WEST SUSSEX COUNTY COUNCIL CONSULTATION

TO:	Arun District Council FAO: Simon Davis
FROM:	WSCC - Highways Authority
DATE:	7 December 2021
LOCATION:	31 Lagoon Road, Pagham, PO21 4TQ
SUBJECT:	P/157/21/PL Demolition & erection of 1 No dwelling (resubmission following P/56/21/PL). This site is in CIL Zone 4 and is CIL Liable as new dwelling.
DATE OF SITE VISIT:	N/A
RECOMMENDATION:	Advice
S106 CONTRIBUTION TOTAL:	N/A

01. Proposed Ground Floor Plan

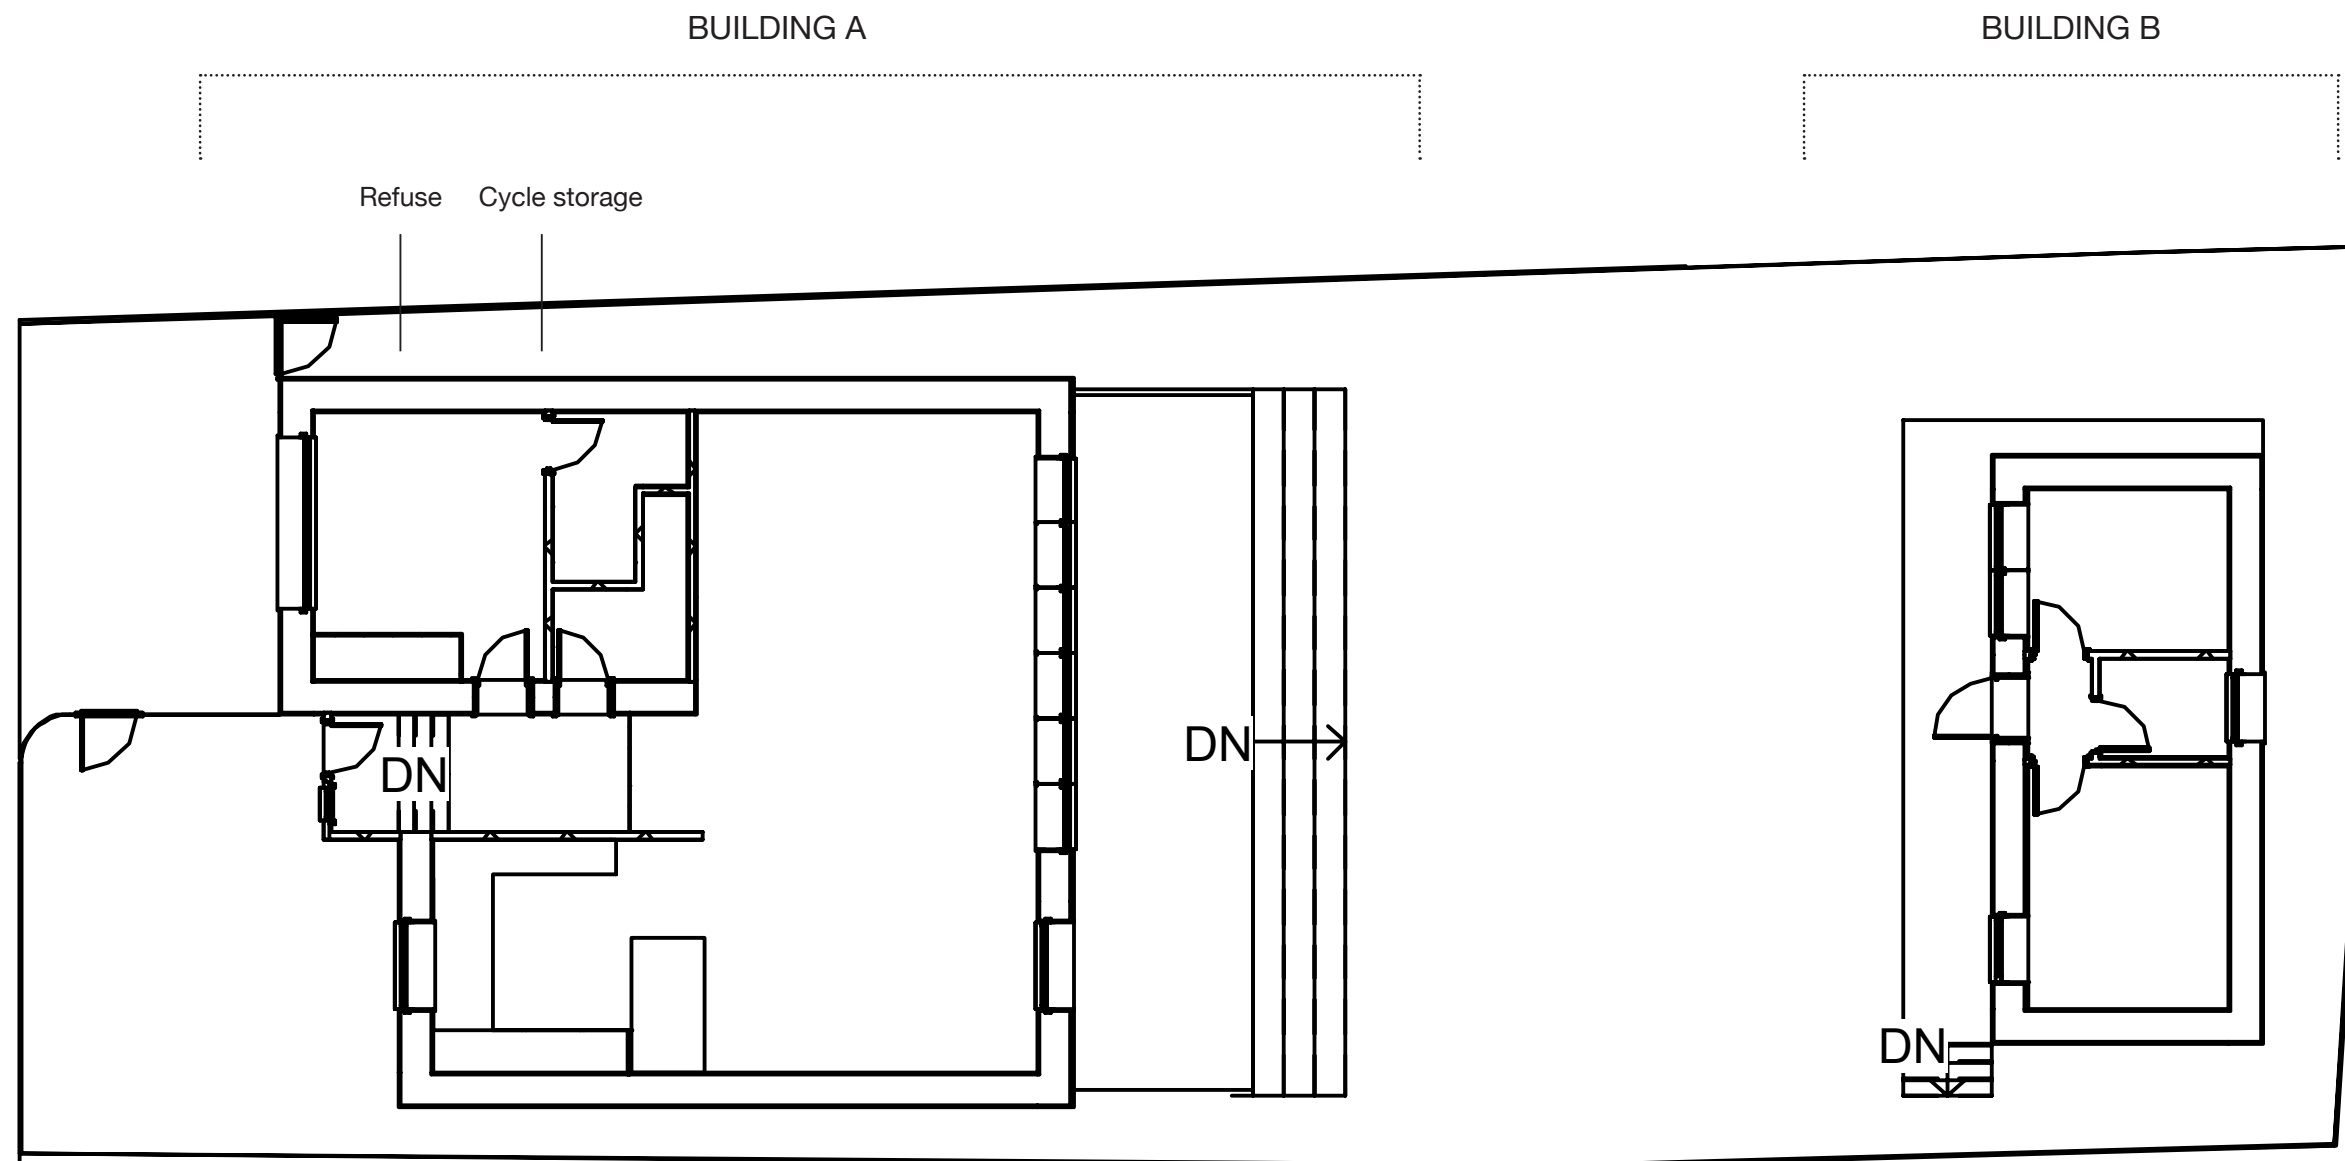
The applicant proposes one car parking space to the front of the proposed dwelling. Under Arun Parking Standards, the LHA would expect a parking provision of two parking spaces for a dwelling of this size in this location. As such, overspill parking would have to be accommodated on-street. Whilst the LHA does not anticipate that the shortfall of one car parking would result in a highway safety concern, the LPA may wish to consider the potential impacts on on-street parking from an amenity point of view.

In the interests of sustainability and as result of the Government's 'Road to Zero' strategy for at least 50% of new car sales to be ultra-low emission by 2030, electric vehicle (EV) charging points should be provided for all new homes. The applicant is advised that for dwellings with an off-street parking provision, 100% of parking spaces should be provided with active EV parking spaces in accordance with the Arun Parking Standards.

Regarding cycles, the applicant proposes cycle parking provision for four cycles. The inclusion of secure and covered cycle parking provision helps promote the use of sustainable transport methods.
